Application for Planning Permission

Development: Demolition of existing garage/offices with associated hard standing and construction of 2 No residential building comprising of 3 No one bedroom houses and 1 No two bedroom house. This application affects the character and appearance of the Littlehampton (River Road) Conservation Area and is in CIL Zone 4 and is CIL Liable as new dwellings.

Location: 25 River Road Littlehampton BN17 5BZ

Proposed Elevation B - B (Scale 1:100)

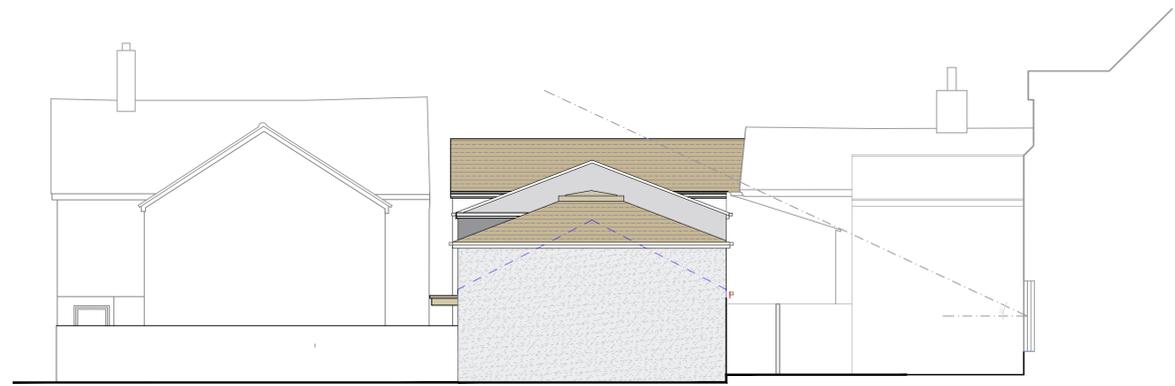
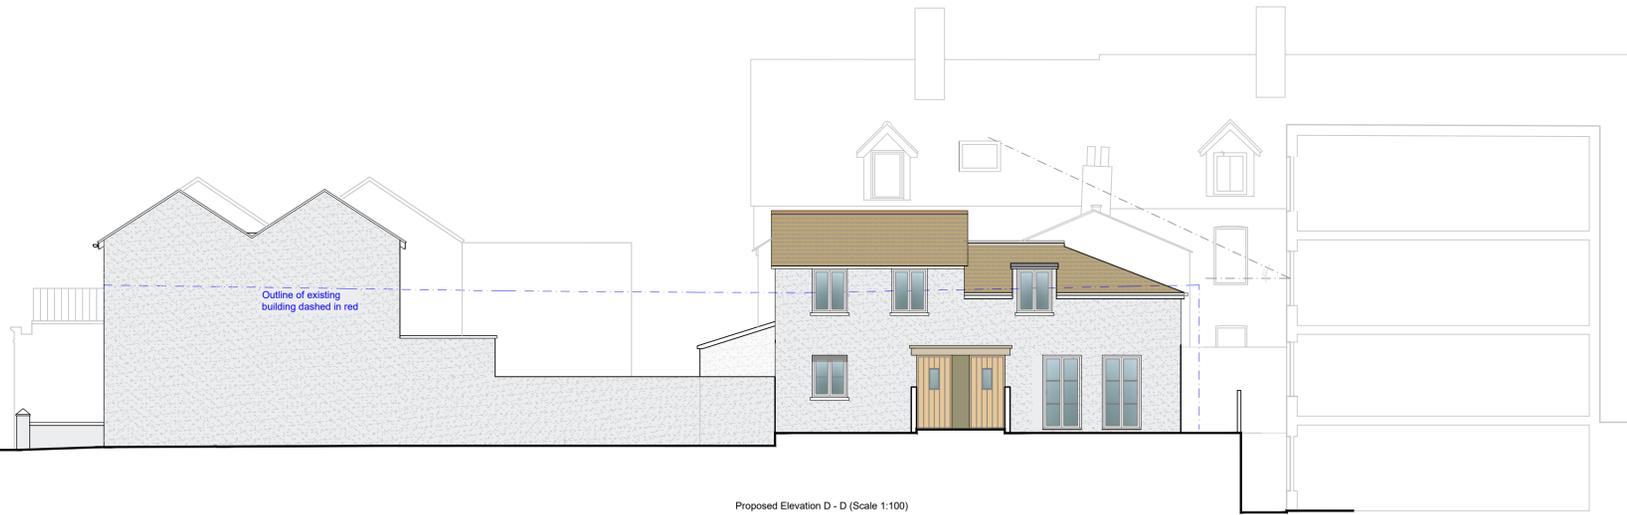
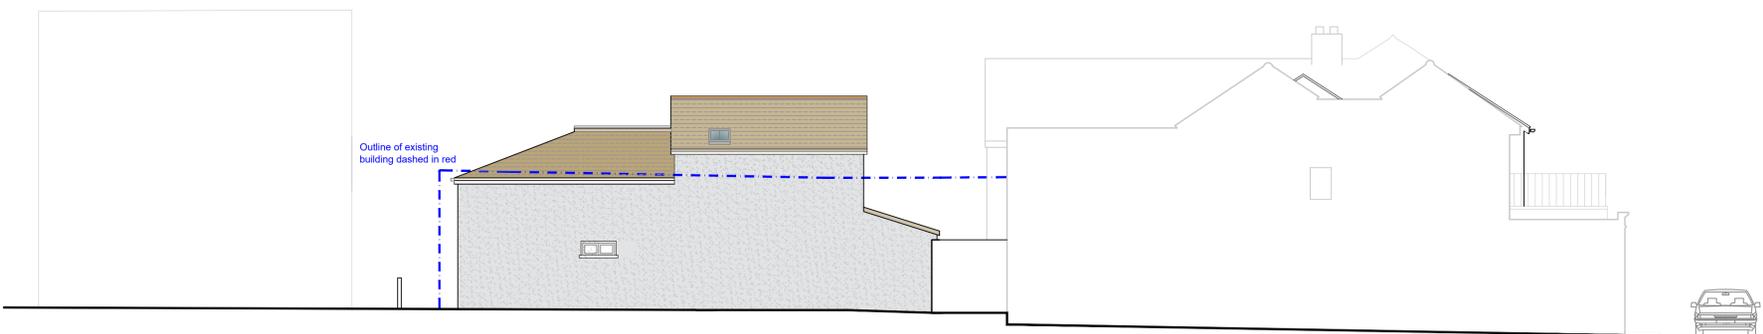
The first floor plan and elevation BB do not accord. Please amend accordingly.
